Sent: 26 July 2012 12:32
To: Planning
Subject: Welwyn Hatfield Council Online Planning - Comment

Application Number: S6/2012/1142/FP

Comment Type: Object

TITLE
PROPOSED
REAR & SIDE ELEVATIONS

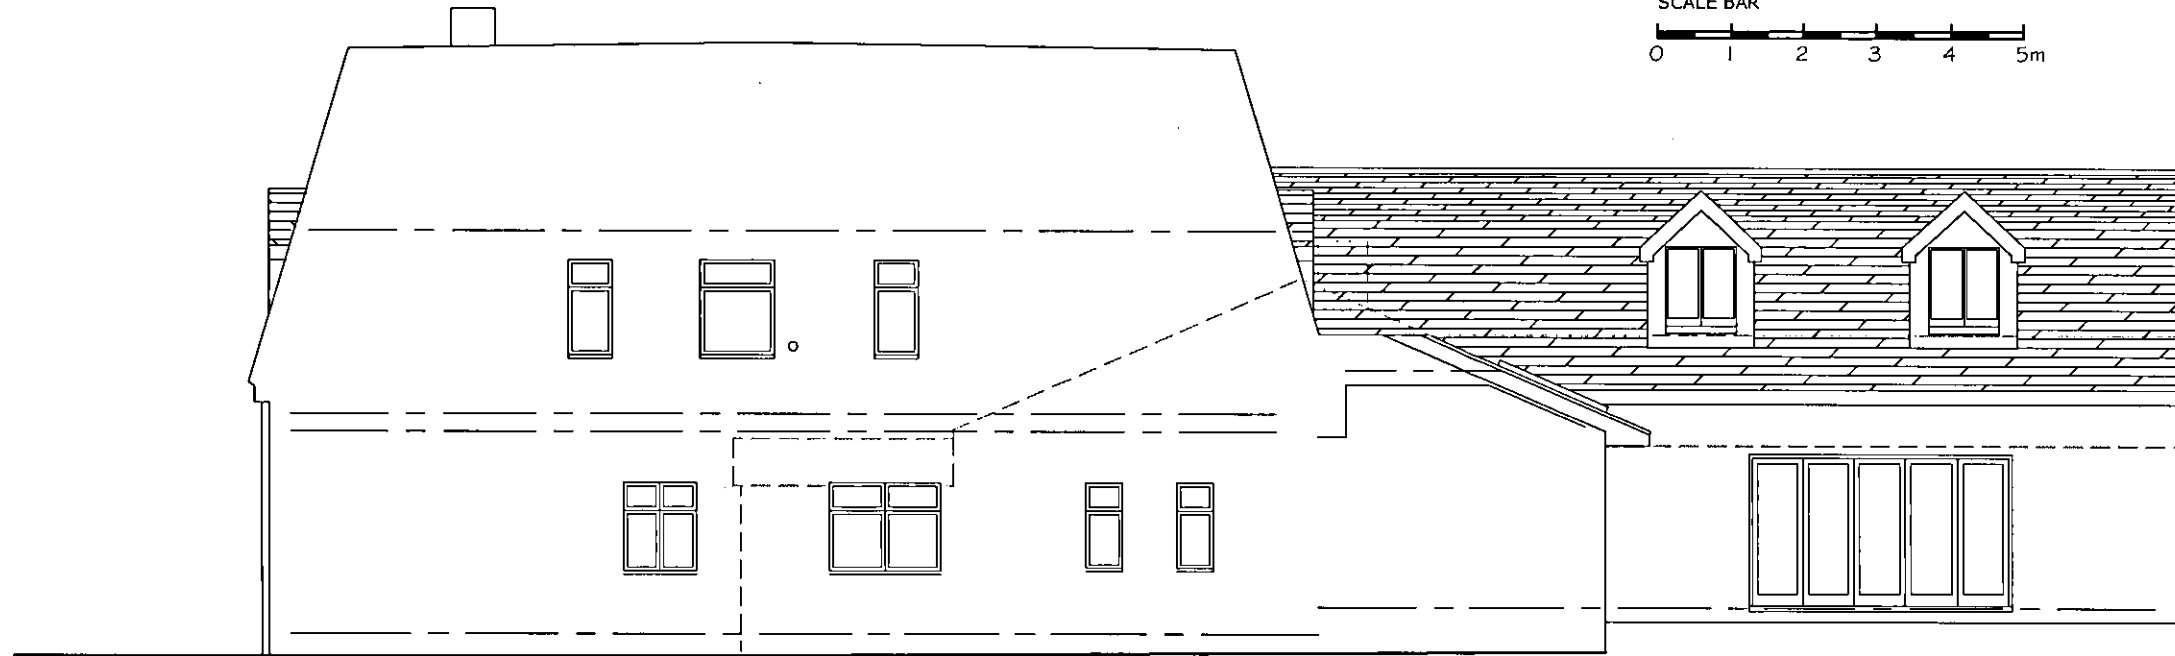
Comment: Whilst we feel that front elevation is acceptable, the rear/side is very oppressive for the adjoining bungalow and surely it would affect their natural light considerably. We feel that this would affect their well being particularly in the summer months.
